Ribble Valley Borough Council  
Housing & Development Control

Your ref 3/2022/0628  
Our ref D3.2022.0628  
Date 6<sup>th</sup> October 2022

Application no: **3/2022/0628**

Proposal: **New vehicular access and parking area within existing garden of 93 Ribchester Road. Increase width of vehicular access to Salesbury Memorial Hall from Ribchester Road including drop kerbs and footpath alterations.**

PROPOSED NEW ENTRANCE

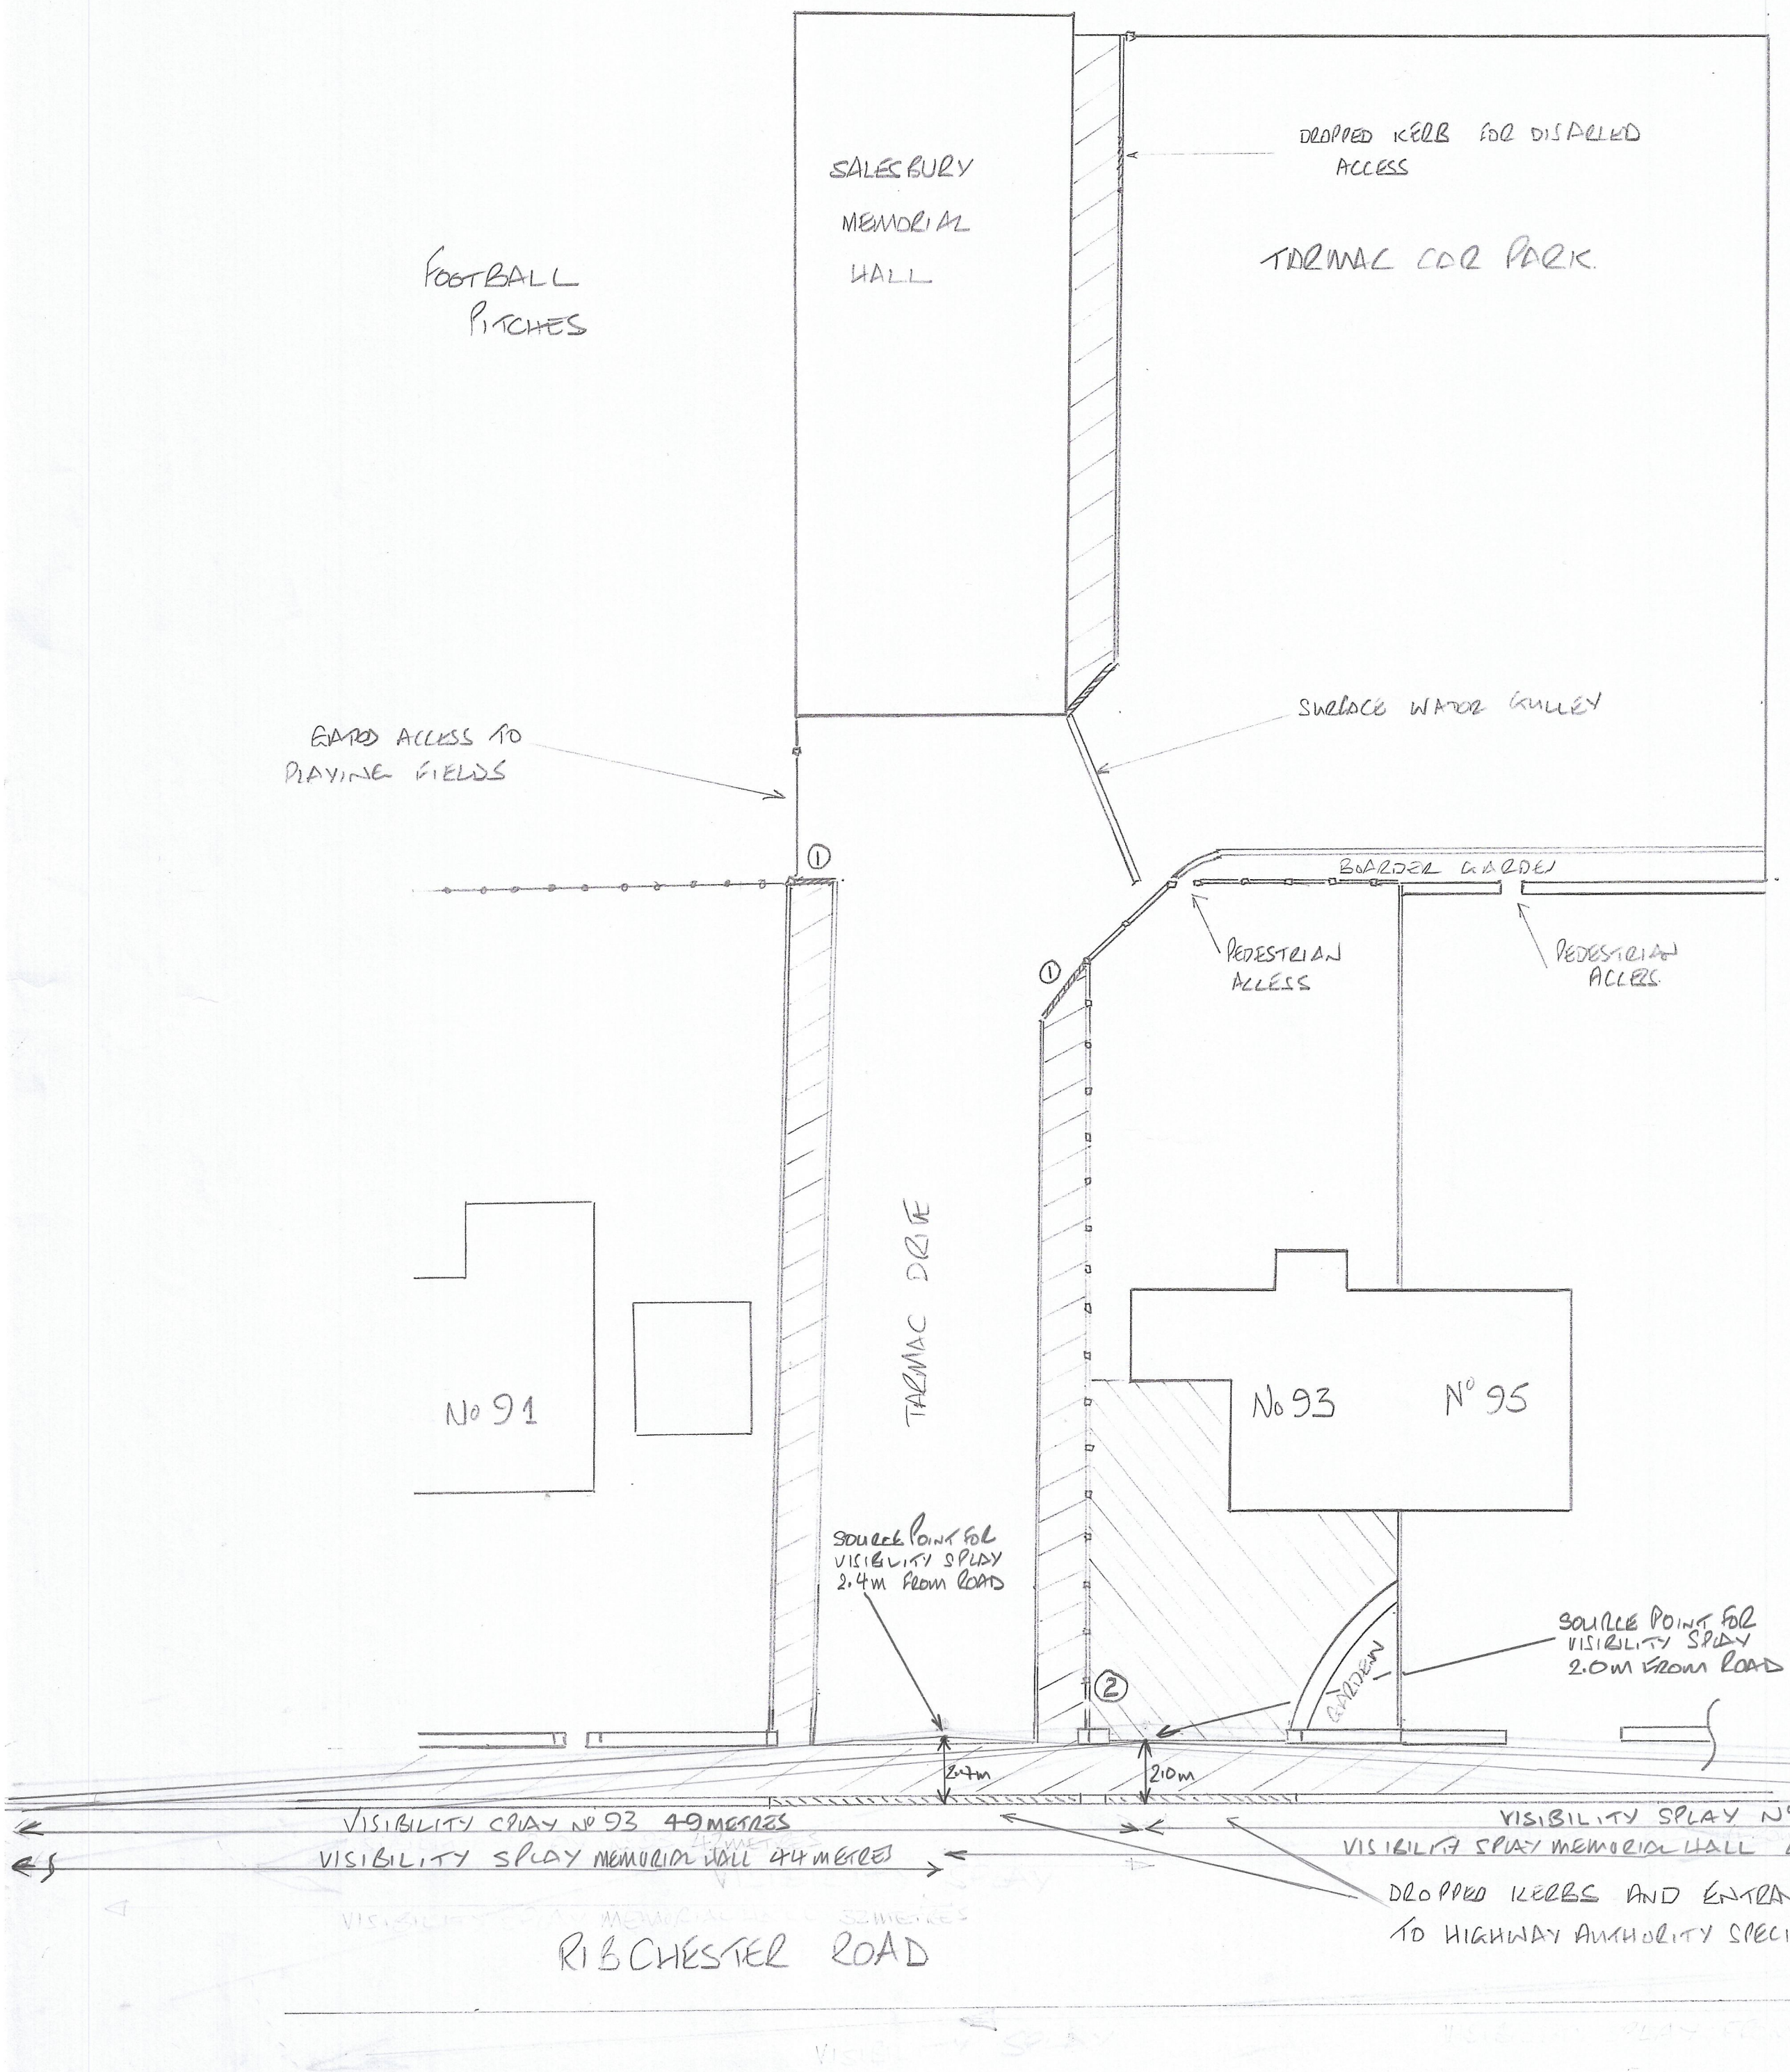
In any case, the LHA have reviewed drawing sheet number 3 of 4 drawing number 155003 titled "Proposed New Entrance," and are aware that the proposed access serving Salesbury Memorial Hall will be approximately 8.4m wide with a 11.75m dropped kerb serving the access, while the dwellings access will be 6.6m wide with a 7.2m dropped kerb. The LHA are aware that the access width for both of the uses comply with the LHAs guidance.

The LHA have further reviewed the drawing and are aware that the access serving the Salesbury Memorial Hall can provide visibility splays of 2.4m x 44m to the right and 2.4m x 43m to the left of the access. While the access serving number 93 Ribchester Road can provide visibility splays of 2m x 49m to the right and 2m x 65m to the left of the access. These visibility splays all comply with the LHAs guidance for a 30mph road and so have no objection to the proposal.

The LHA do, however, advise the Agent and Applicant that should the proposed access for either the dwelling or the Memorial Hall conflict with the gully, street sign or telegraph pole, they will need to be relocated which will be at the full cost of the Applicant. While the H bar located at Salesbury Memorial Halls access will have to be extended. These works can all be undertaken along with the extension to the access under a Section 278 agreement.

1. No part of the development hereby permitted shall be occupied until such time as the access arrangements shown on drawing sheet number 3 of 4 drawing number 155003 titled "Proposed New Entrance," have been implemented in full.

2. No part of the development hereby permitted shall be occupied until such time as vehicular visibility splays of 2.4 metres by 43 metres have been provided at the access serving Salesbury Memorial Hall and vehicular visibility splays of 2 metres by 43 metres have been provided at the access serving number 93 Ribchester Road. These shall thereafter be permanently maintained with nothing within those splays higher than 0.9 metres above the level of the adjacent footway/verge/highway.
